ENG-SF22036-R1-CDs.pdf Markup Summary

Subject: SW - Textbox
Page Index: 1
Date: 1/24/2023 12:40:52 PM
Author: Glenn Reese - EPC Stormwater
Color: ■
Layer:
Space:
Page Label: [1] 1 118323-TITLE-01 - Layout1

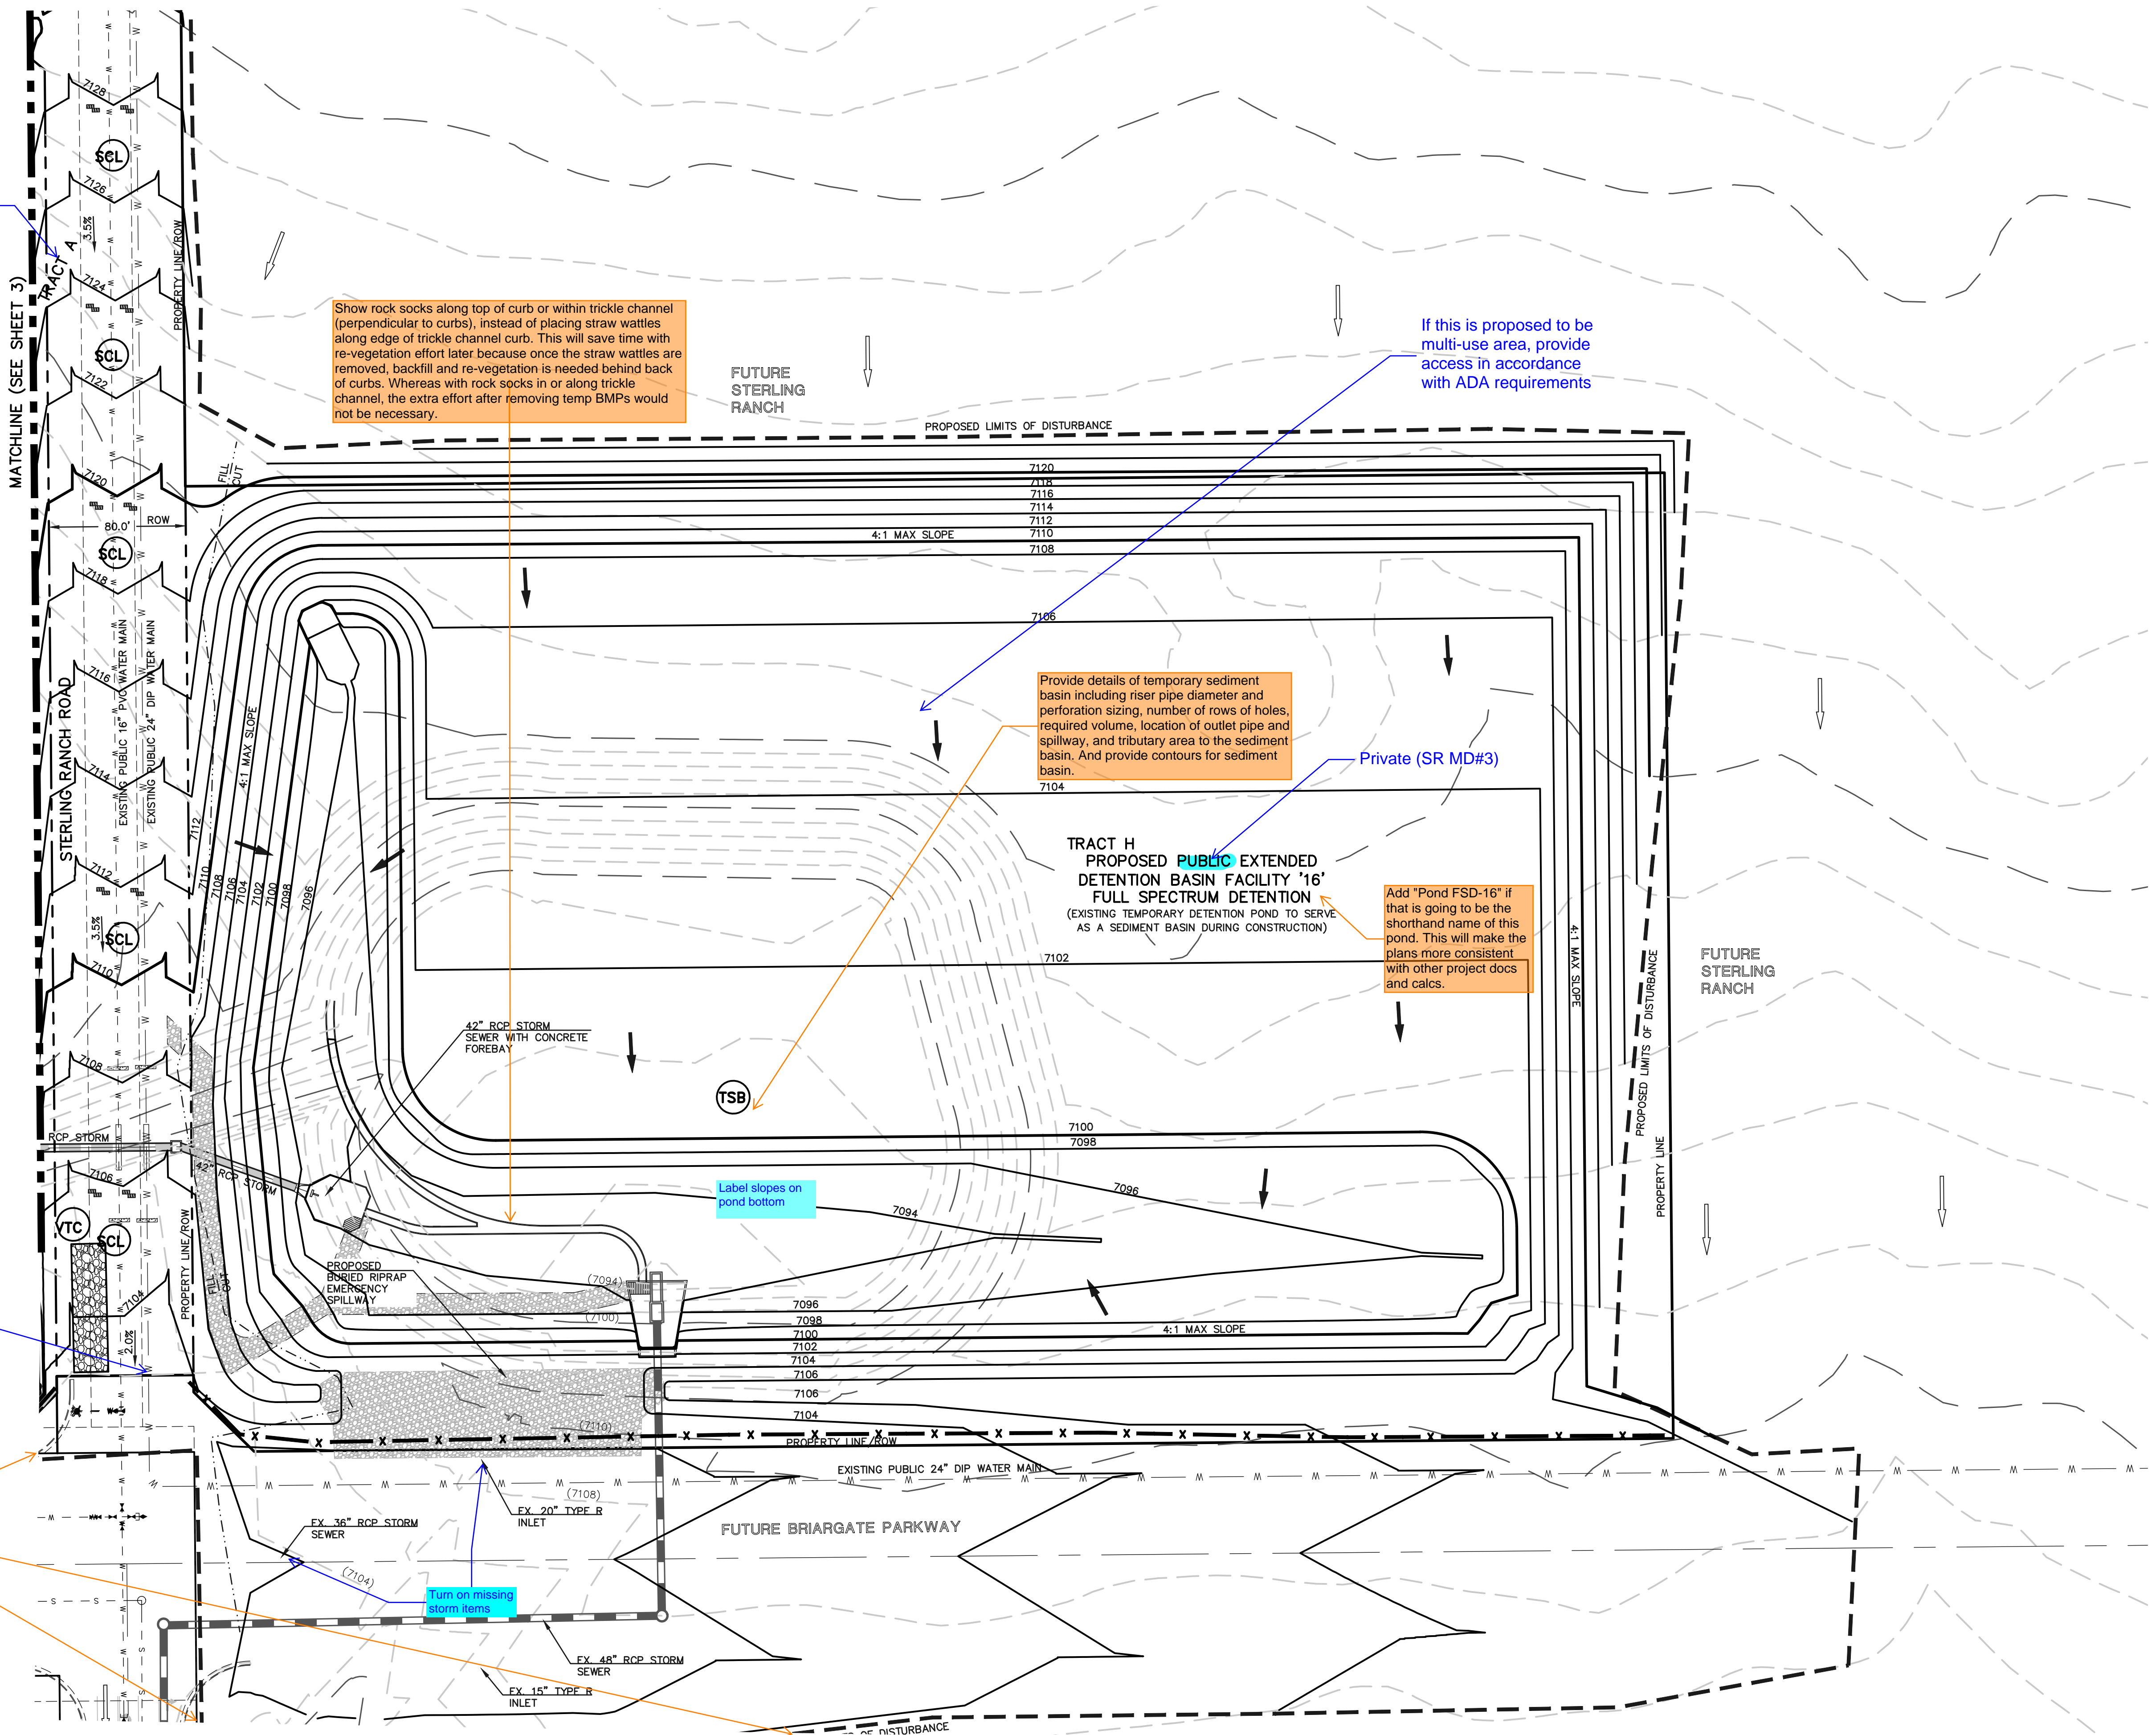
Add "Pond FSD-16" if that is going to be the shorthand name of this pond. This will make the plans more consistent with other project docs and calcs.

Private (SR MD#3)

Verify road width per PUDSP comments
